Engineers Comments Regarding Condition 4

NOTIFICATION FROM ARUN DISTRICT COUNCIL

APPLICATION NO: A/132/19/DOC

Registered: 30-SEP-19
Site Address: Merry England Nursery Dappers Lane Angmering BN16 4EN
Description of Works: Approval of details reserved by condition imposed under ref A/142/16/OUT relating to Condition Nos 4 - surface water drainage, 6 - flows to watercourses, 7 - SuDs system, maintenance of any watercourse, 11 - Construction Management Plan, 12 - road safety audit, 14 - ecological, 17 - tree protection and 21 contamination.

INFILTRATION CALCULATED FROM 75%-25% WATER DEPTH RANGE

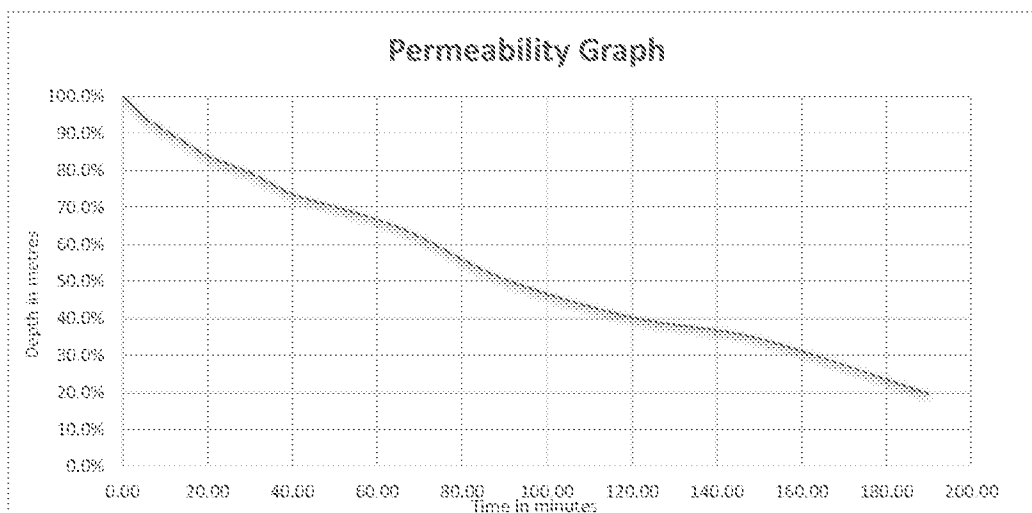
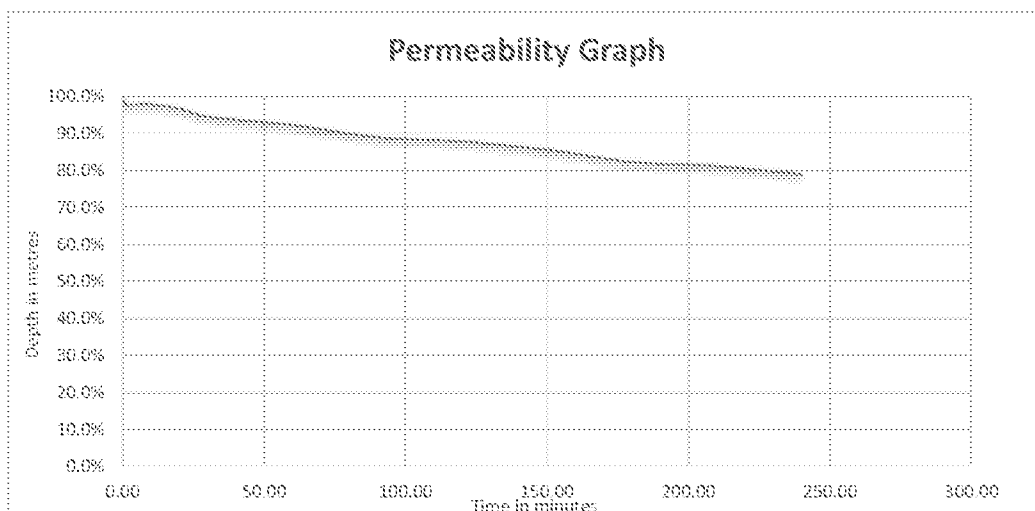
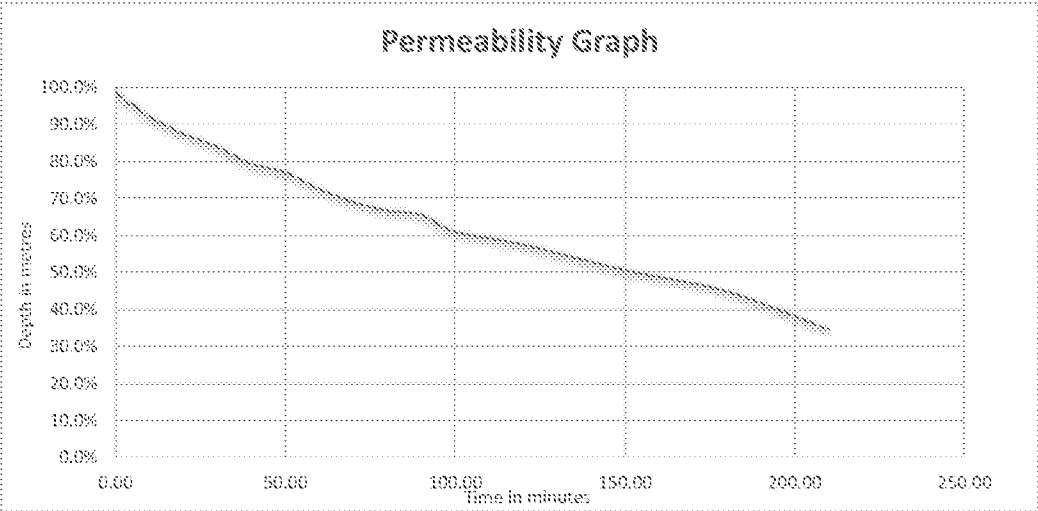
Due to time restrictions on site during the geotechnical testing, the geotechnical engineers only managed to perform one test for all three trial pits. Only TP1 drained fully with TP2 and TP3 being extrapolated. The results from TP1 was satisfactory however TP2 and TP3 were poor and should full testing have been carried out all results would have been poorer during the third test. Therefore, a full infiltration solution was discounted in favour of a hybrid solution i.e. partial discharge and infiltrating porous surfaces. This seems to be the most pragmatic approach given the varied geology.

DRAINAGE LEGEND (1:200)

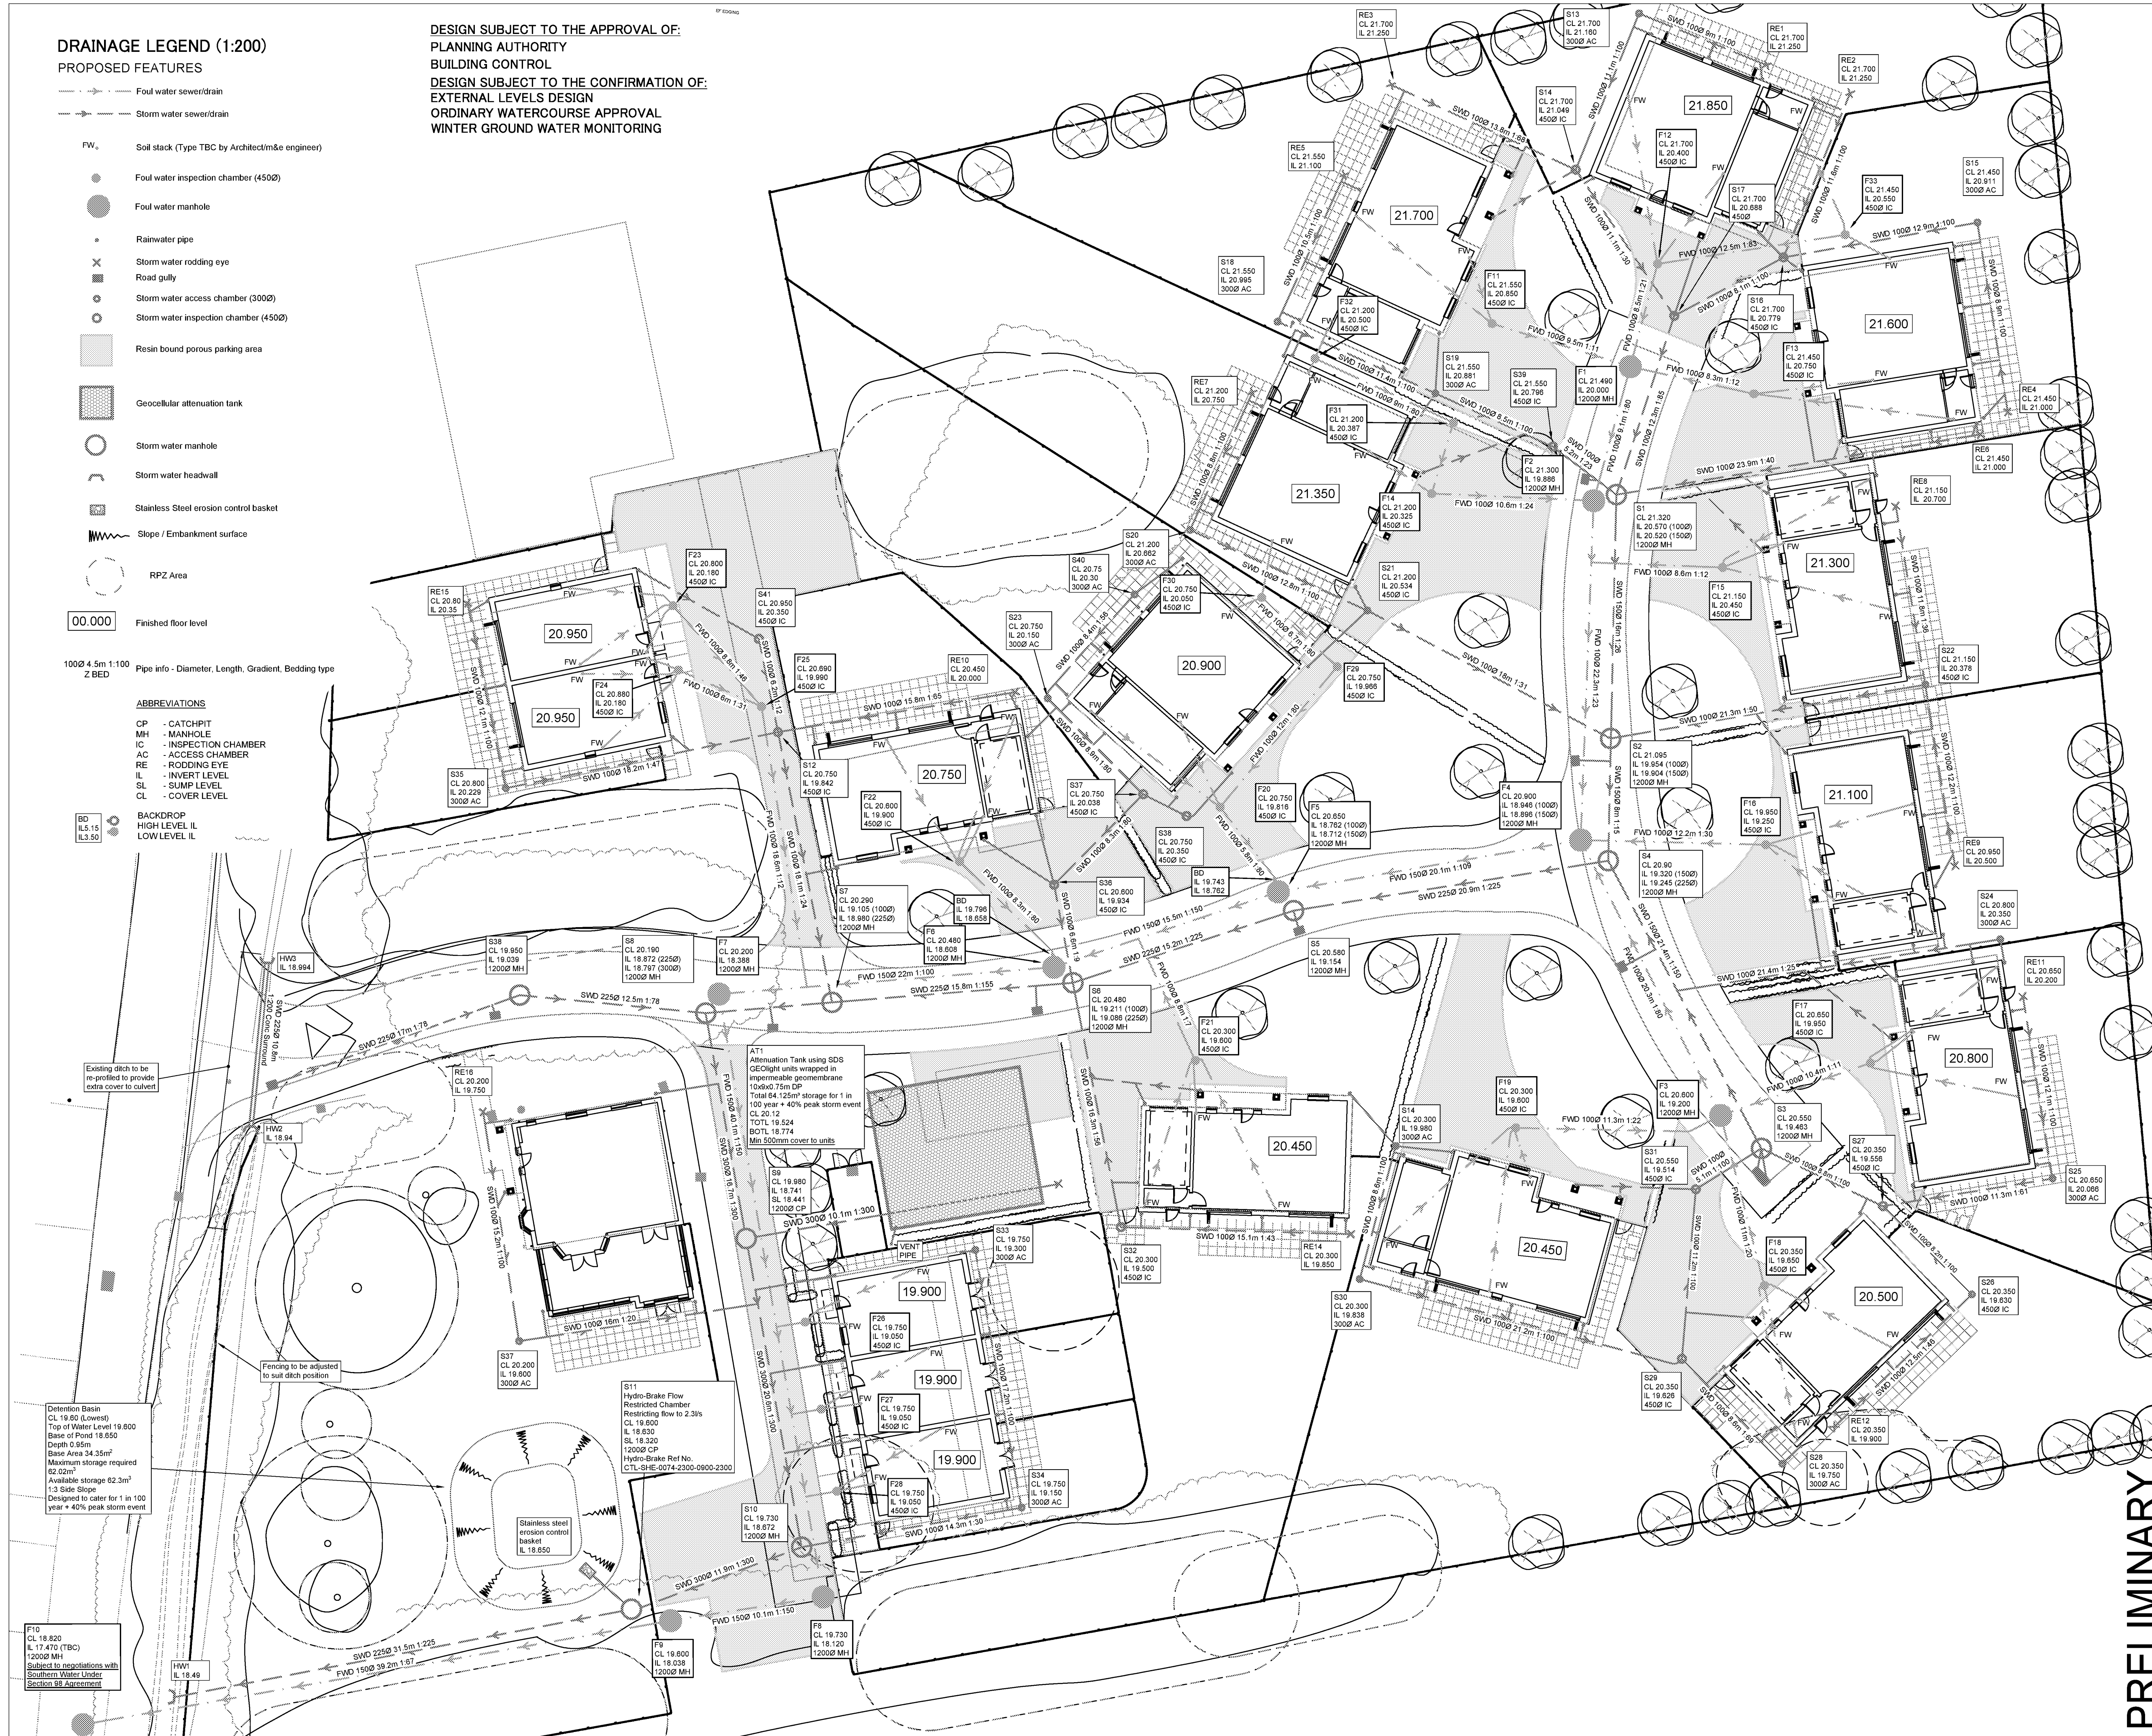
No winter groundwater monitoring or infiltration testing results have been submitted. It is not appropriate to review the surface water drainage strategy without this information.

It is not possible to review the proposed flows to watercourse until it has been proven if infiltration is viable or not.

Please find attached revised drainage design package issued for approval following on from the winter testing.
